From: Annette Simpson [REDACTED]
Sent: 18 June 2018 09:49
To: Anita Gardner
Cc: Karen Hilton
Subject: RE: Planning Consultation on: LU/67/18/PL

WEST SUSSEX COUNTY COUNCIL CONSULTATION

TO:	Arun District Council FAO: Mrs A Gardner
FROM:	Highways, WSCC
DATE:	31/05/2018
LOCATION:	14-18, Surrey Street, Littlehampton, West Sussex, BN17 5BG
SUBJECT:	LU/67/18/PL Change of use of part of public highway for external seating area at front comprising of 4 No. tables & 8 No. chairs. This application may affect the setting of a listed building. More information.

PROPOSED PAVEMENT CAFE

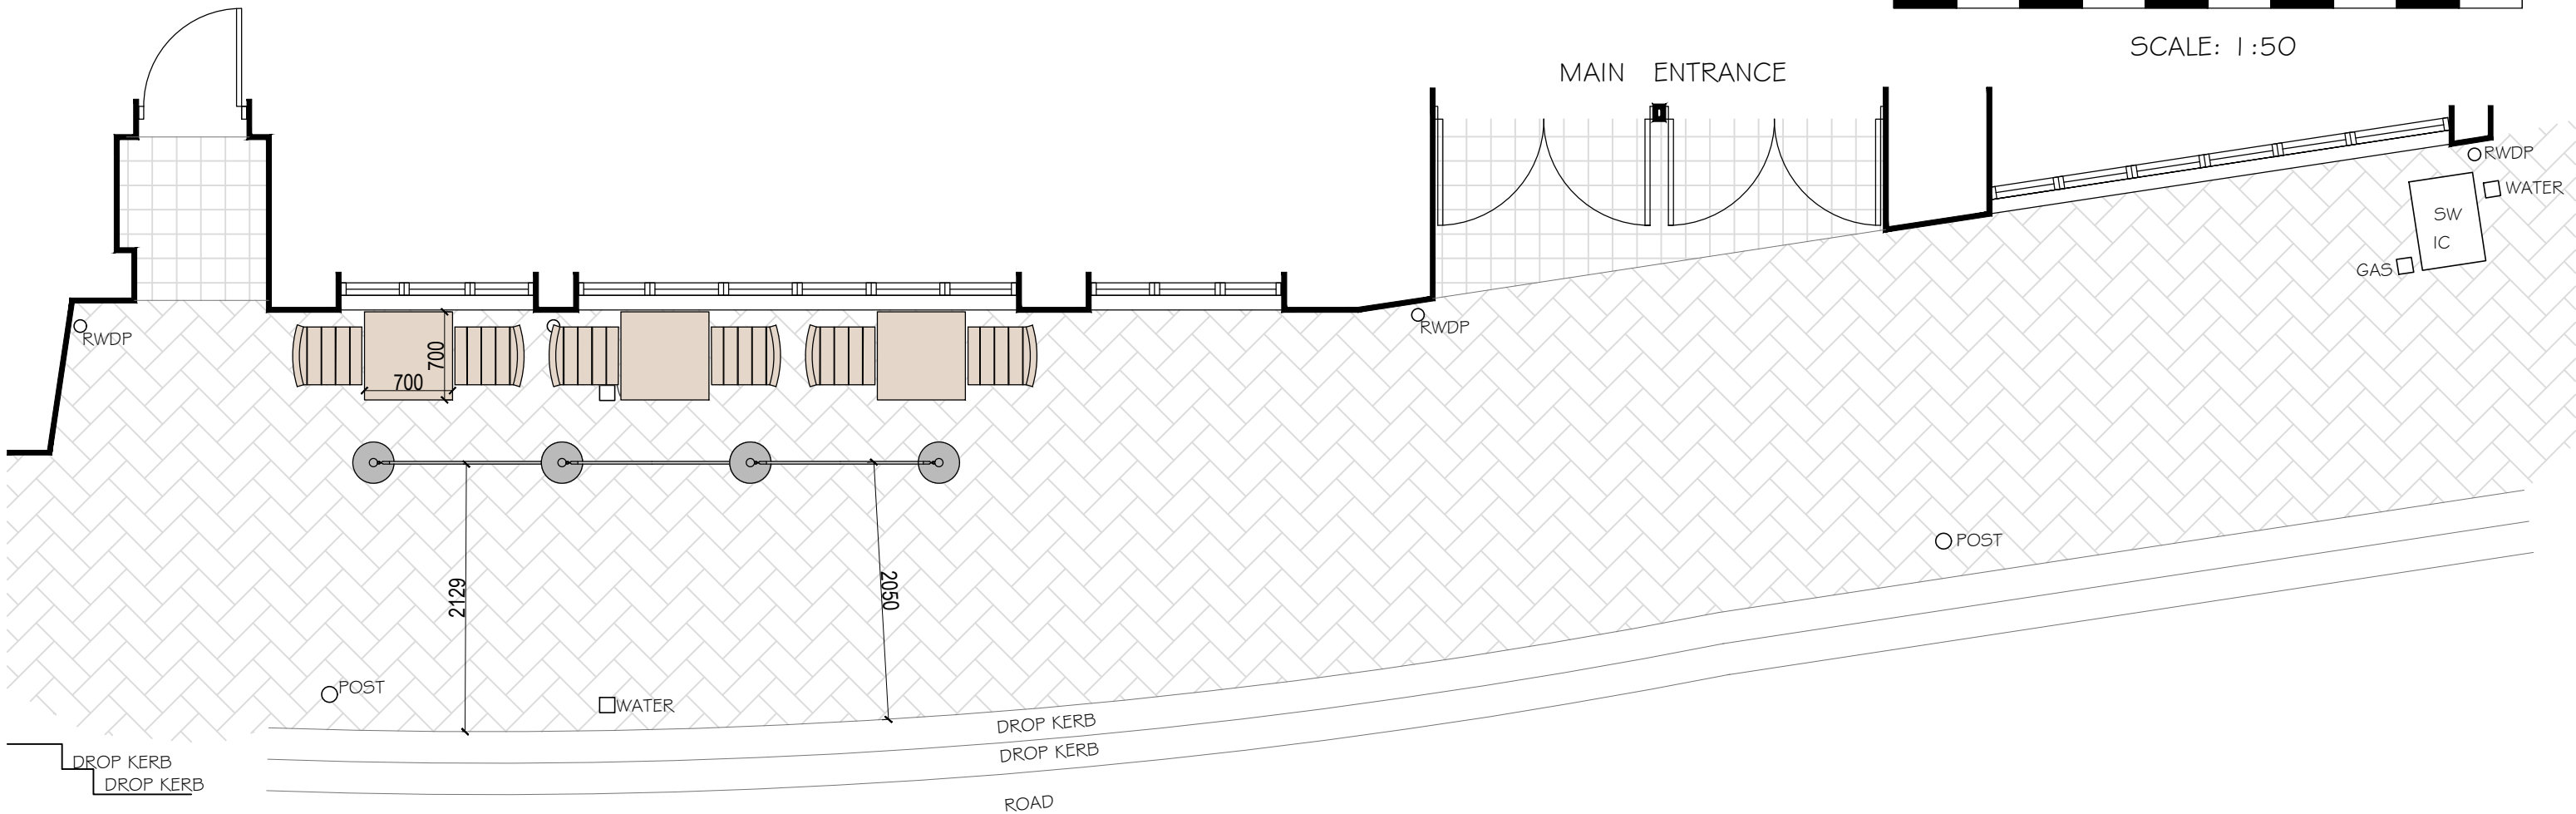
After inspection of the revised plans the proposed would still result in a narrowing of the footway to circa 1.8 metres once the stands for the rope and pole barriers have been taken into consideration.

A post is annotated at the southern extent of the frontage, using desktop evidence this post was removed some when between 2014 and 2015. The applicant should check this detail and remove this annotation if the post is no longer in place.

The Local Highways Authority would reiterate that Manual for Streets advises a minimum footway width of 2.0 metres. This is expanded upon in section 3.1 of the DFT publication 'Inclusive Mobility' which states the following regarding footway widths:

“A clear width of 2000mm allows two wheelchairs to pass one another comfortably. This should be regarded as the minimum under normal circumstances.”

The footway width in this location currently accords to recognised guidance. The Local Highways Authority would therefore not wish to seek any reduction below recognised guidance and standards.

I note the frontage of the public house does provide the opportunity to provide a reduced level of tables and chairs while retaining minimum acceptable footway widths across the frontage as advised above. The Local Highways Authority would advise that the rope and pole barriers are removed or pushed back to provide maximum footway with and/or further reducing the quantity of tables and chairs provided.

I would ask the applicant investigate modifying the proposal in line with the comments above. In its current form the Local Highways Authority would not be minded to support this application and any subsequent licence application to place tables and chairs would likely fail.

Thank you for your email. Please find attached further amended plans which will hopefully now satisfy all
concerned. However, I look forward to hearing from you should you require any further information or
amendments.
